**RE: Independence Square
Project 1005517 18DRB-70021**

The following are the DRB comments we received from the original hearing on February 14th along with our response in bold print for revision clarification.

ENGINEER'S SEAL	INDEPENDENCE SQUARE ALBUQUERQUE, NM	DRAWN BY pm
	LOT 1 AND LOT 2 GRADING PLAN	DATE 1-16-18
VINCENT P. CARRICA P.E. #16212	TERRA WEST, LLC 5571 MIDWAY PARK PL NE ALBUQUERQUE, NEW MEXICO 87109 (505) 858-3100 www.tierrawestllc.com	DRAWING 2017093-GRB
		SHEET # 1
		JOB # 2017093

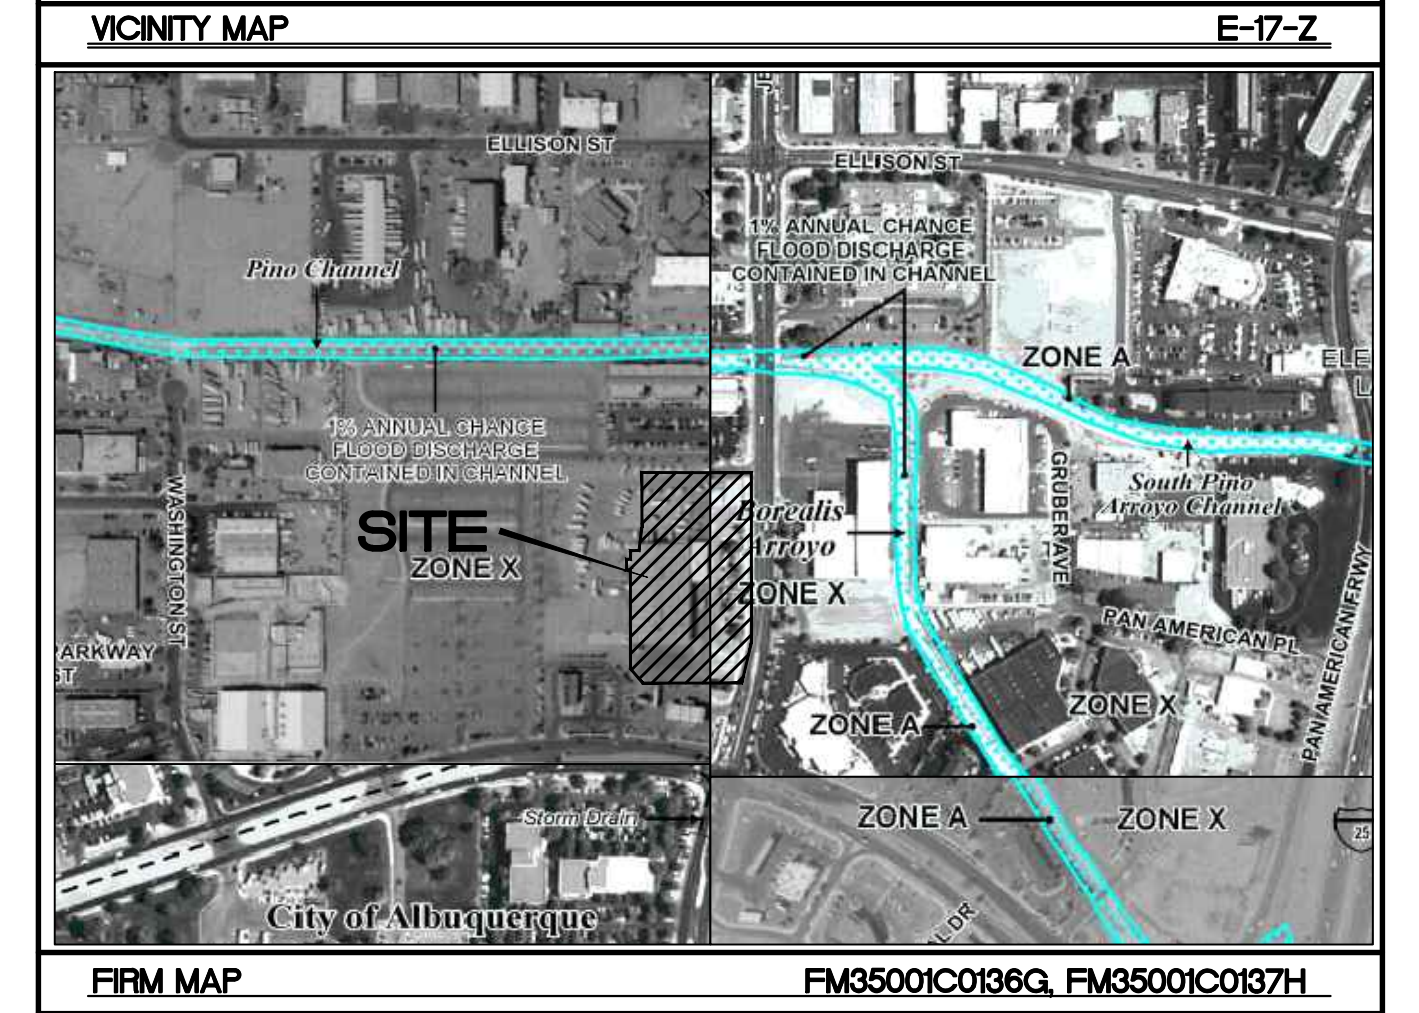
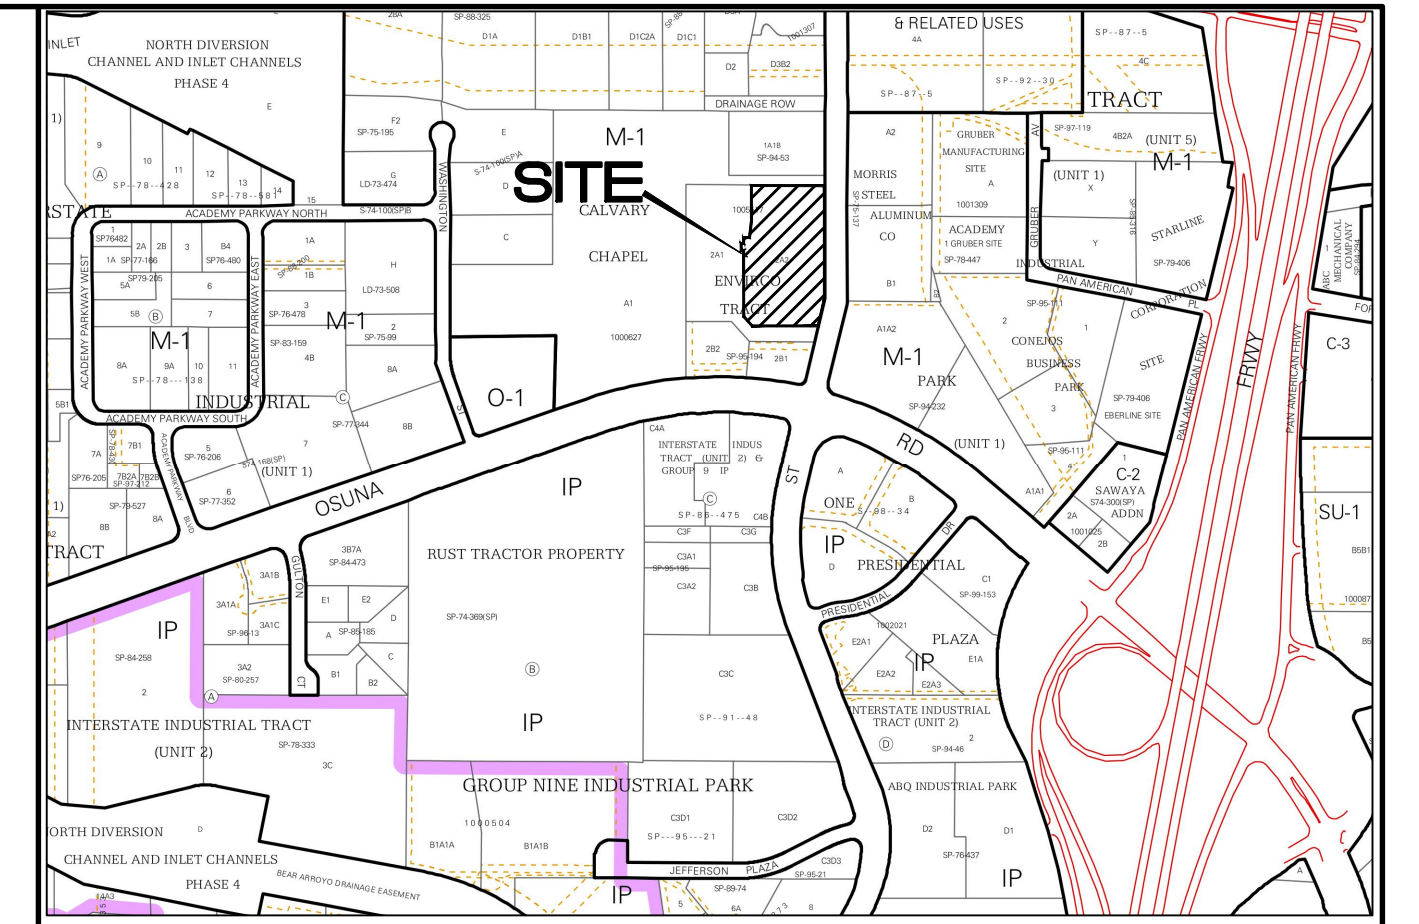
- Hydrology approved a G&D Plan with engineer's stamp dated 1-3-2018 for Grading Permit and Building Permit. The G&D Plan in the Site Plan for Building Permit is dated 1-16-2018 and the engineer's stamp is missing. Did the plan change after it was approved?
 - o If so it must be resubmitted to Hydrology with a new engineer's stamp date on it.
 - o If not then the 1-3-2018 plan must be approved by Hydrology for Site Plan for Building Permit, and that plan must be included in the Site Plan for Building Permit.

Please see Hydrology approval letter dated 2/21/2018 included with this revised package.

ENGINEER'S SEAL	INDEPENDENCE SQUARE ALBUQUERQUE, NM	DRAWN BY pm
	LOT 1 AND LOT 2 MASTER UTILITY PLAN	DATE 1-16-18
VINCENT P. CARRICA P.E. #16212	TERRA WEST, LLC 5571 MIDWAY PARK PL NE ALBUQUERQUE, NEW MEXICO 87109 (505) 858-3100 www.tierrowestllc.com	DRAWING 2017093-MUB
		SHEET # 2
		JOB # 2017093

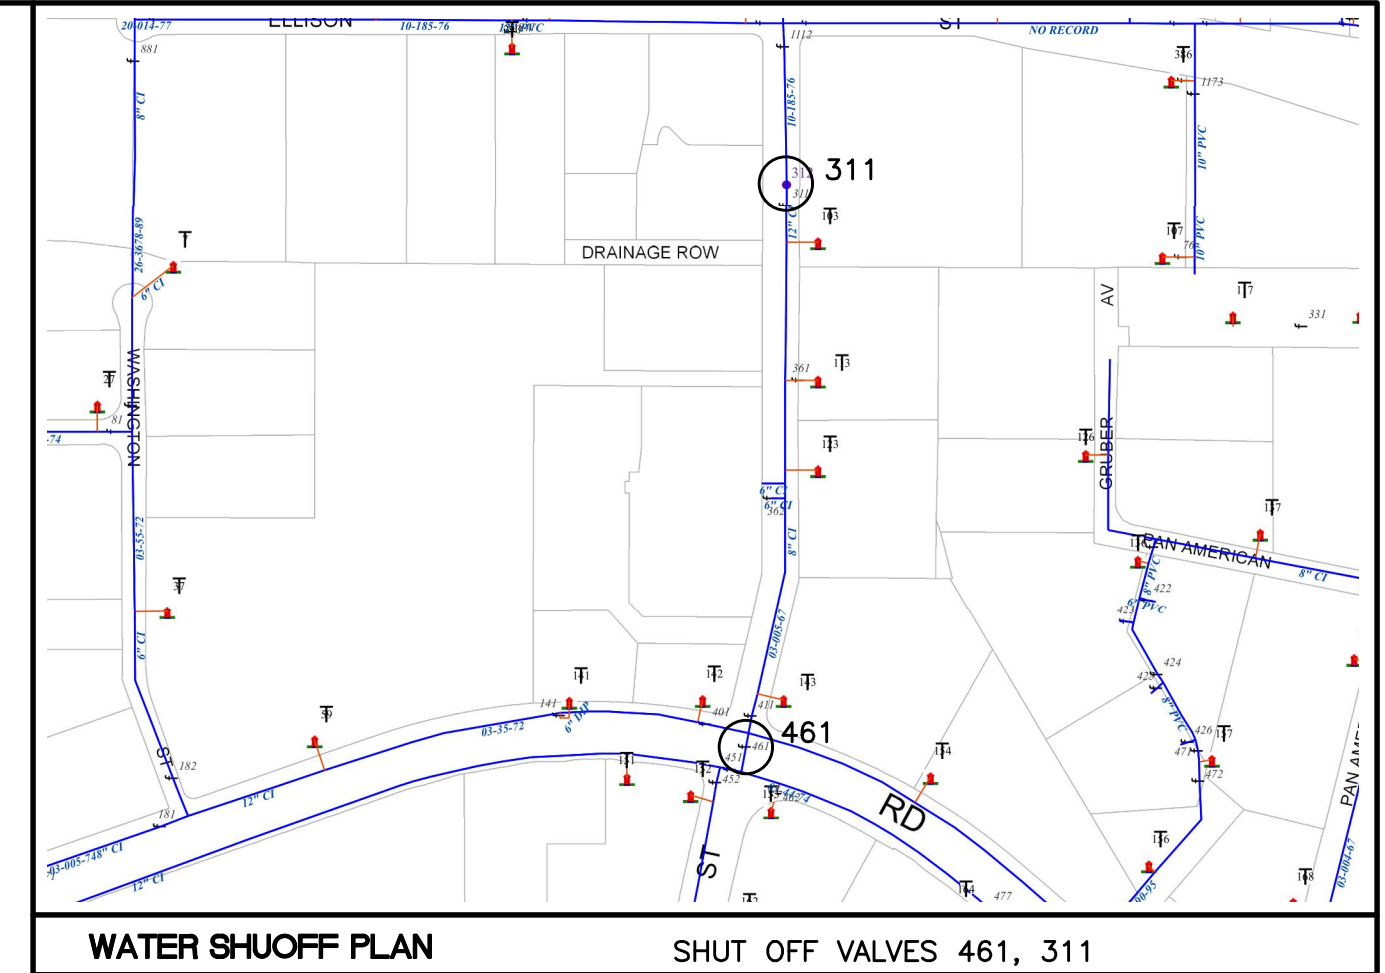
2. The nature of the site utility plan public vs. private water and sanitary sewer facilities is confusing and will be sorted out during preparation of the availability statement. The Site Utility Plan will need to be consistent with the availability statement and the Fire 1 plan and must clearly identify the public and private water and sanitary sewer utilities. An approved infrastructure list may be required.
Confusion is partially due to past improvement being accepted but not input into their GIS mapping system. Clarification should come with the issuance of the availability letter. No public improvements are required and no infrastructure list is required.
